Application No: FP/182/20/HH
Site Address: Gulls 7 First Avenue Felpham PO22 7LG
Description of works: Single storey rear extension to replace existing conservatory with revised roof to existing single storey extension, first floor rear extensions, single storey glazed canopy to south side elevation

Thank you for your internet representation made on 14th December 2020 which has been recorded as an objection with the comments as follows:

Job No: 3249
Dwg No: P_02 A

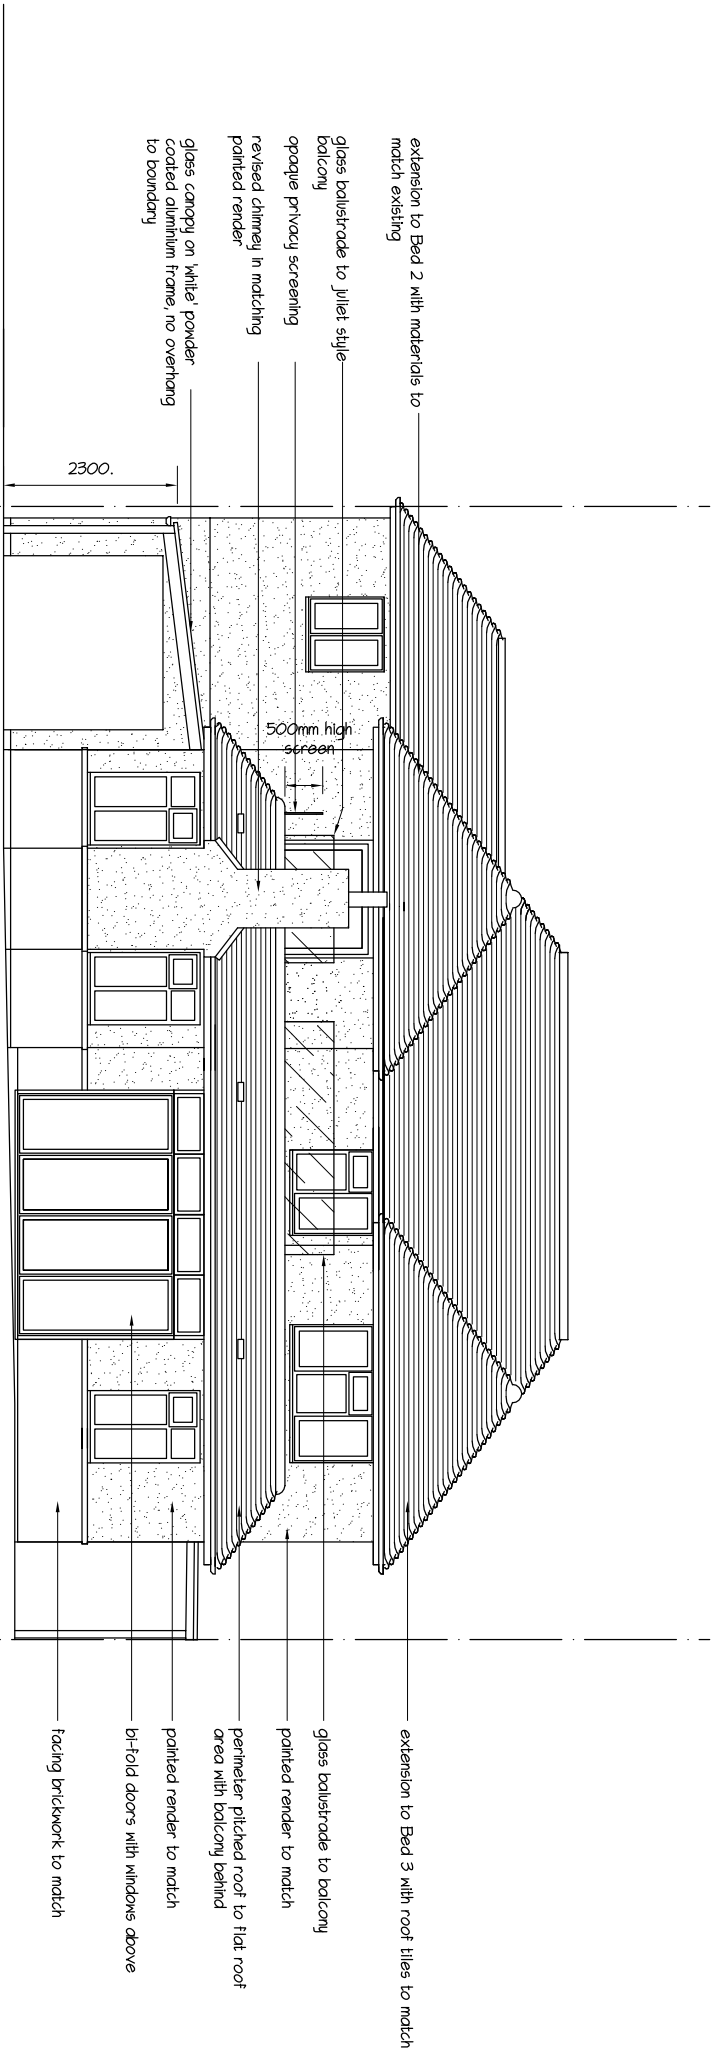
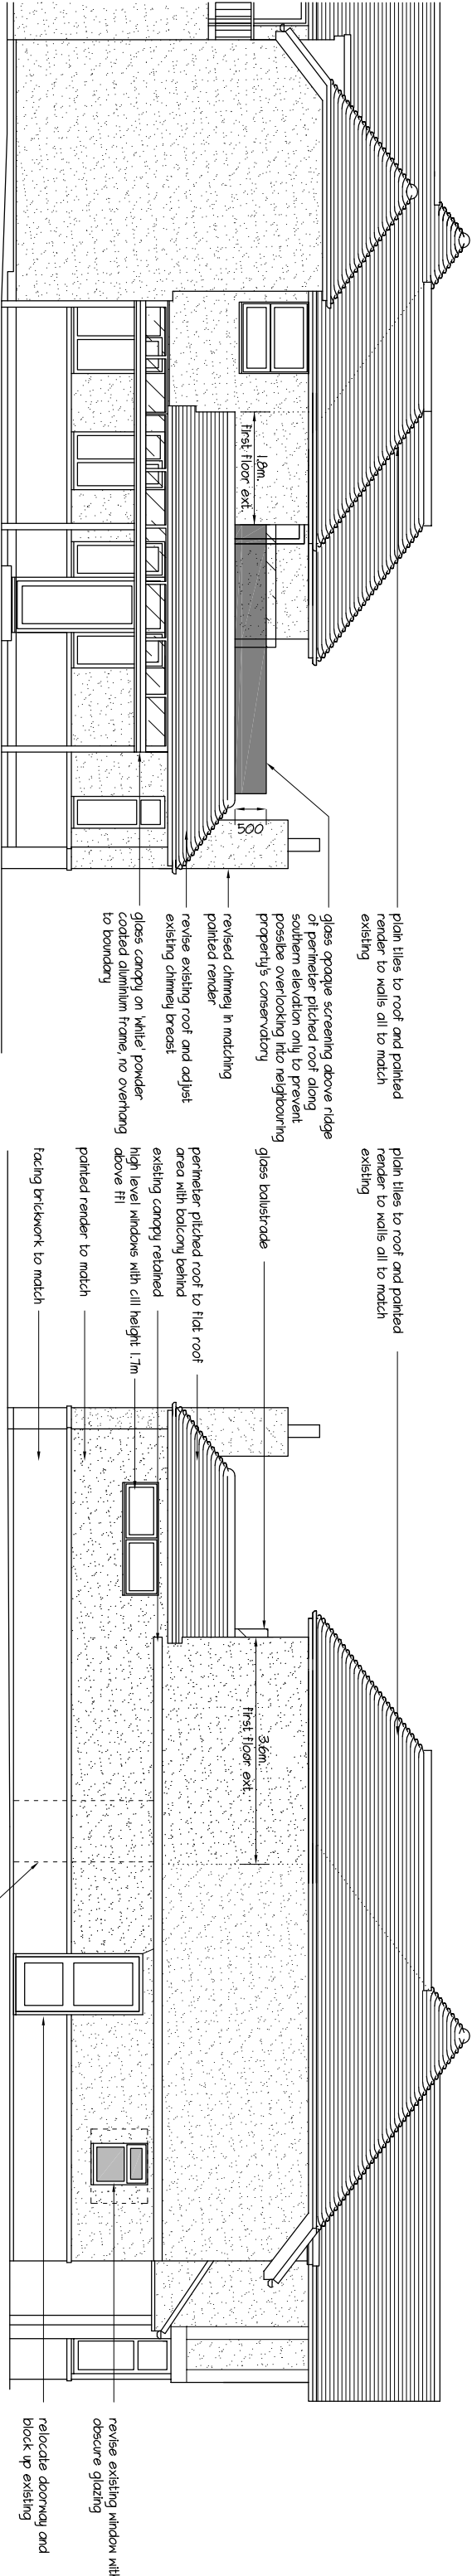
Having viewed the amended plans we are still concerned about being overlooked. The drawings show a glass screen 500mm above the roof line, this screen needs to be obscured and higher (1.8m from 1st floor level) to prevent being overlooked from bedroom 2 extension.
